# **MEMORANDUM**

Re: *Comments on SEP16-015*  
*Comments on ZTR16-002*  
*Location of the Property: Southwest corner of 77<sup>th</sup> Avenue SE and SE 32<sup>nd</sup> Street, Mercer Island, WA 98040*

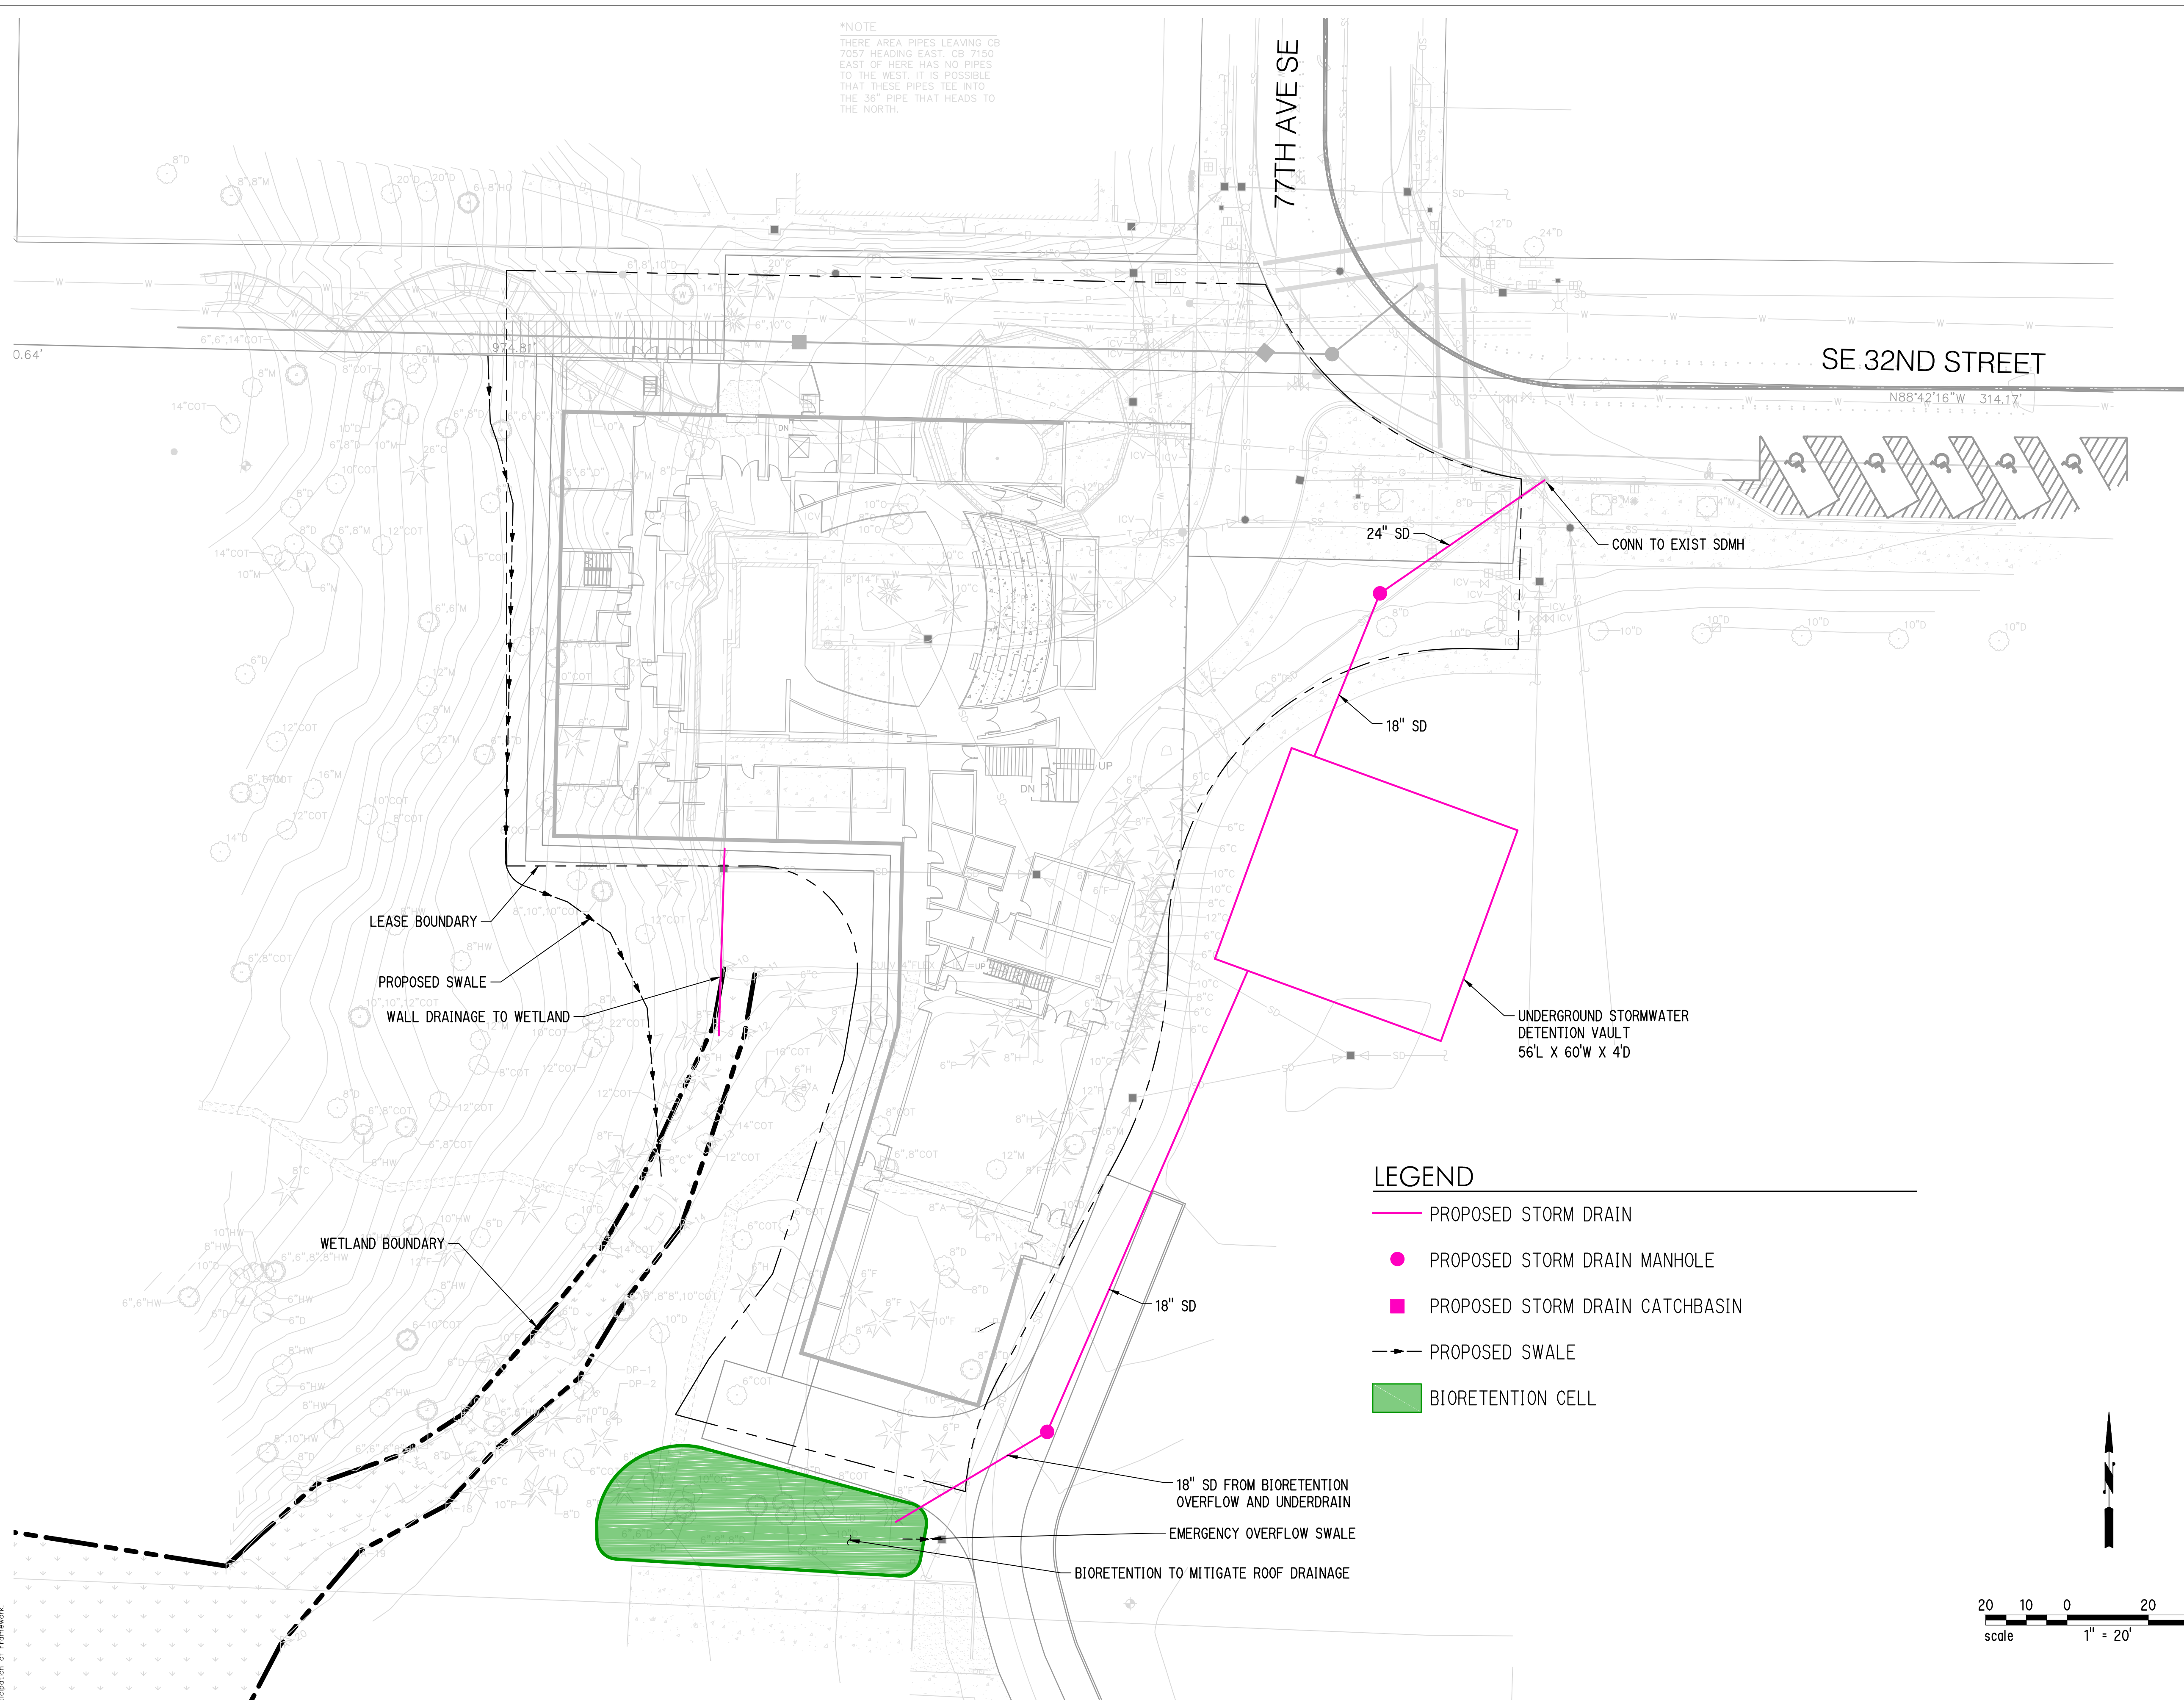
4. Water Runoff
  - a. The SEPA Checklist § B, Q. 3 subsection c(1) contemplates a bioretention area, an underground stormwater detention vault and related drains *outside* of the lease boundaries. *See* SEPA Checklist Attachment M. There is no authority for MICA to build necessary building elements on city land without a lease for that specific area.
  - b. The SEPA Checklist § B, Q. 3 subsection d contemplates a “proposed swale that will be strategically graded into the hillside” *outside* of the lease boundaries. *See* SEPA Checklist Attachment B. There is no authority for MICA to build necessary building elements on city land without a lease for that specific area.
